**COLORADO**  
**Department of Transportation**  
Region 2

Access Permit No. **222165/166**  
85-87/El Paso County

RE: Bradley Point Site Development Plan

BRADLEY POINT FILING NO. 1-DRY SUBDIVISION SITE DEVELOPMENT PLAN

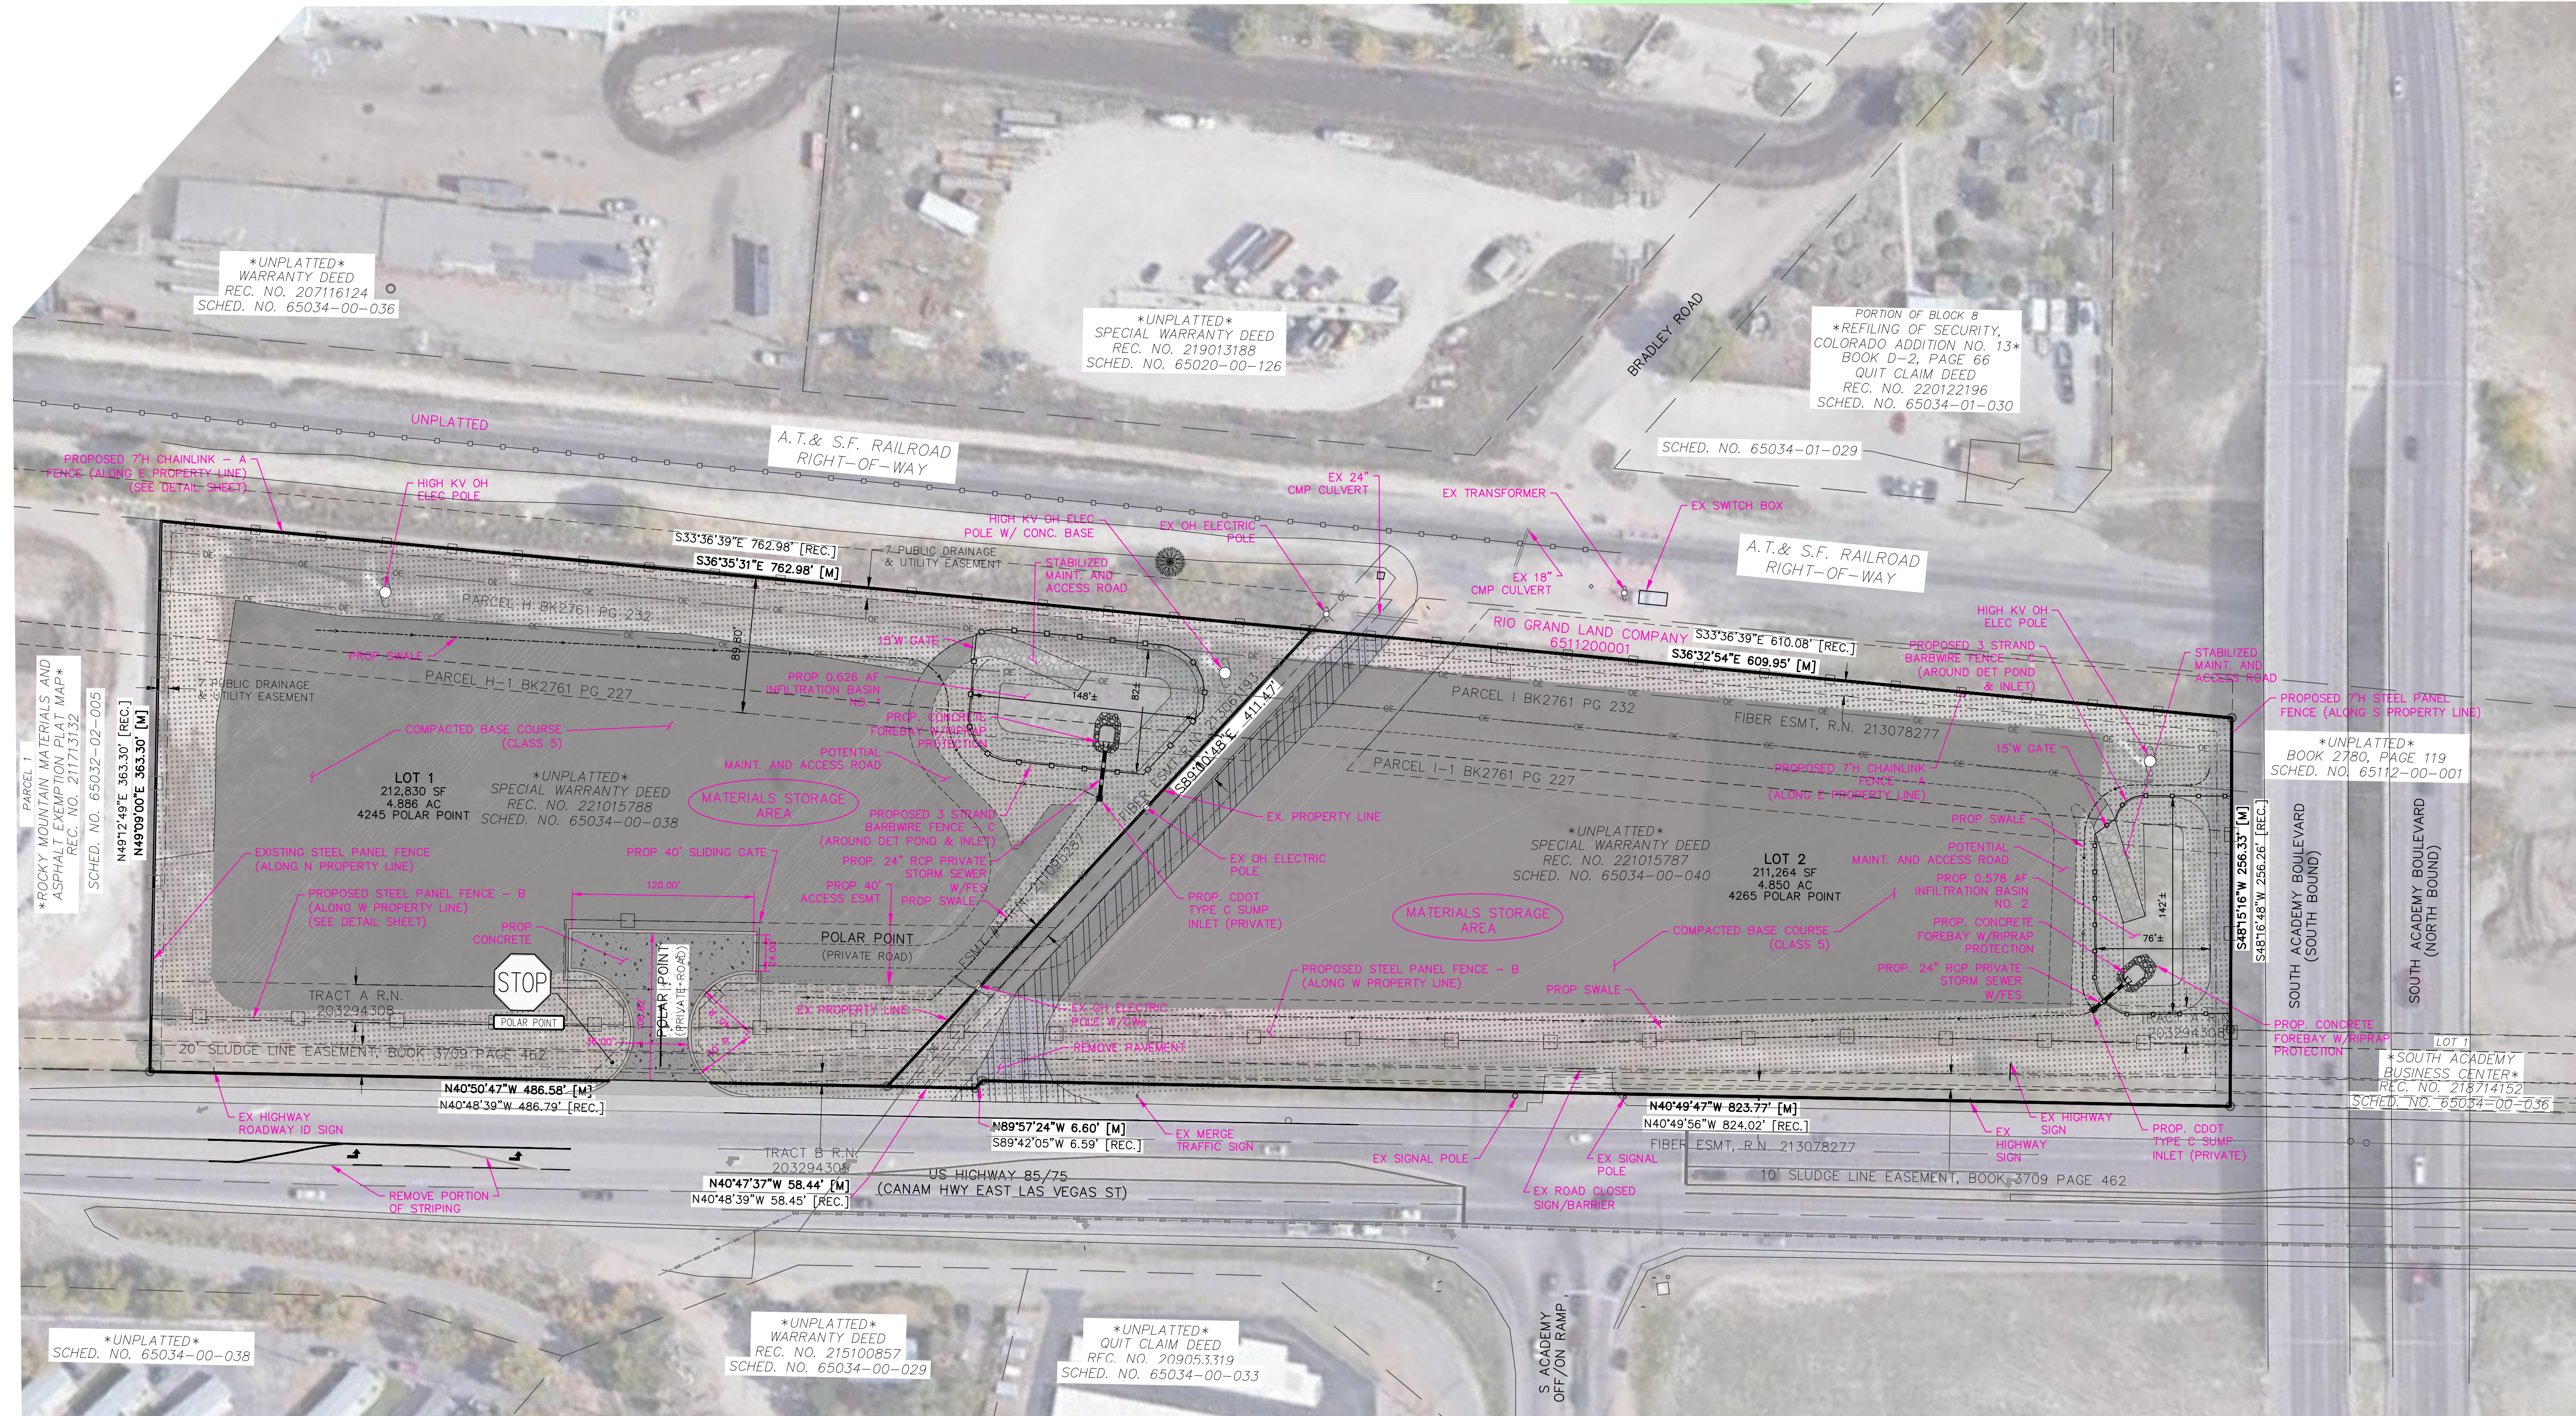
- As a condition of the access permit the permittee will be required to re-stripe a southbound left turn deceleration lane into the site where the existing painted median exists.
